June 29, 2020

Re: Footing outside Middle Third  
305 Southern Place  
Lillington, NC

To: Harnett County Inspections

CONCRETE BLOCK PIER DETAIL
 not to scale

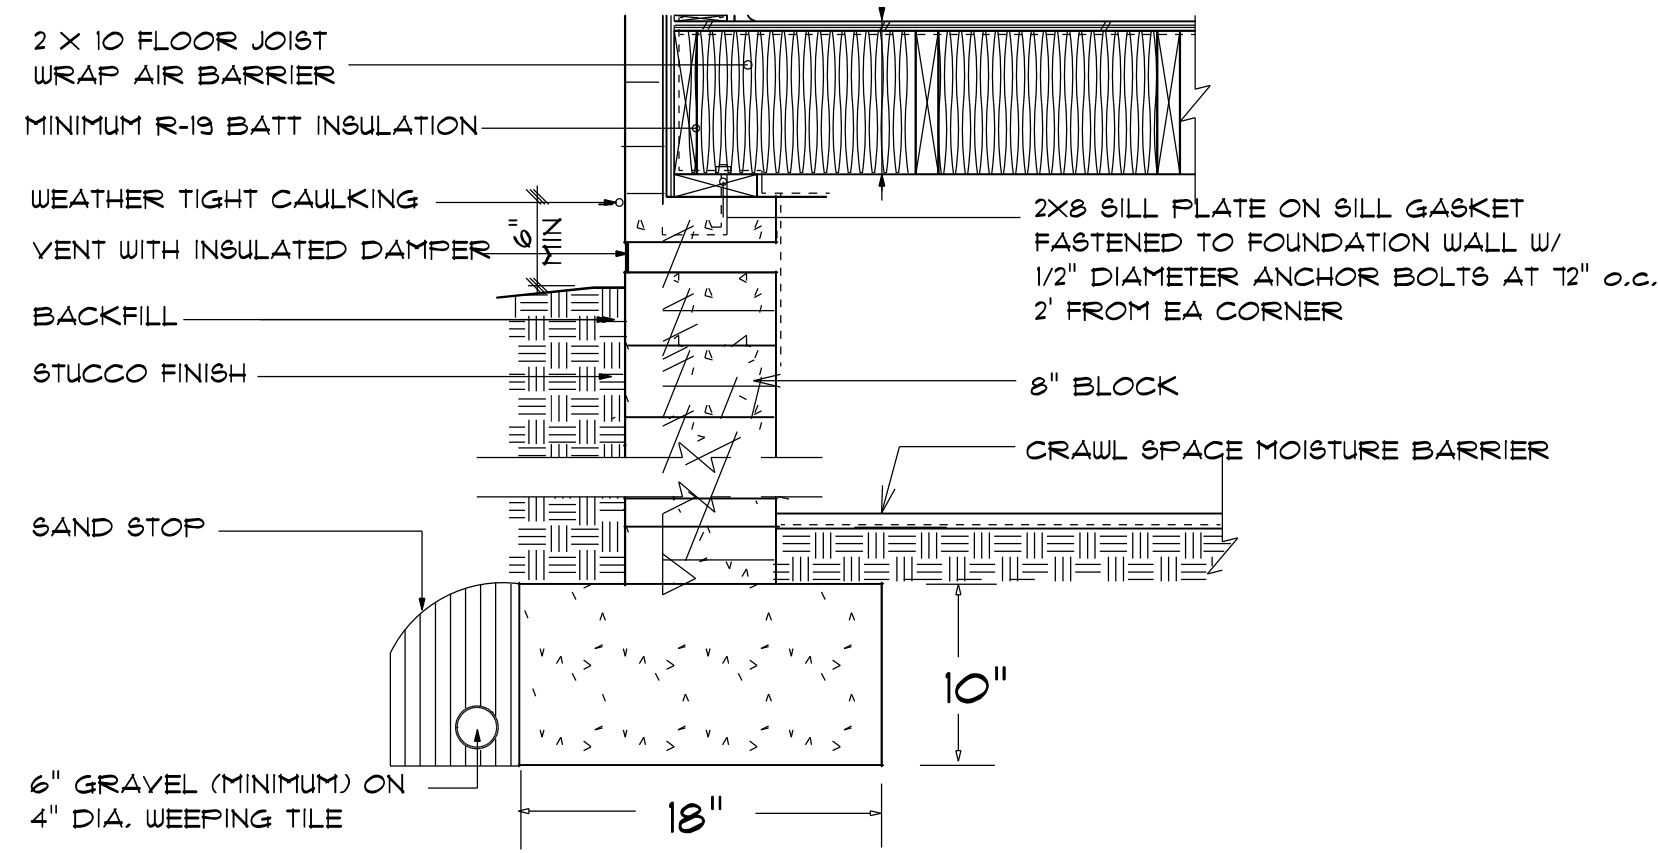
On June 24, 2020 I made an onsite visit to 305 Southern Place located in Lillington, North Carolina. The purpose of this visit was to inspect the pier foundation footings in which the resultants were outside the middle third of the footing.

It is a good practice, in general to have the resultant located within the middle third. However in a foundation on a very incompressible soil or a low loading such as in this case, the resultant can be allowed to fall outside the middle third.

I will certify that the resultant loading will not induce over turning or excessive settlement on sections of the footing. If I can be of any more assistance, please feel free to contact me.
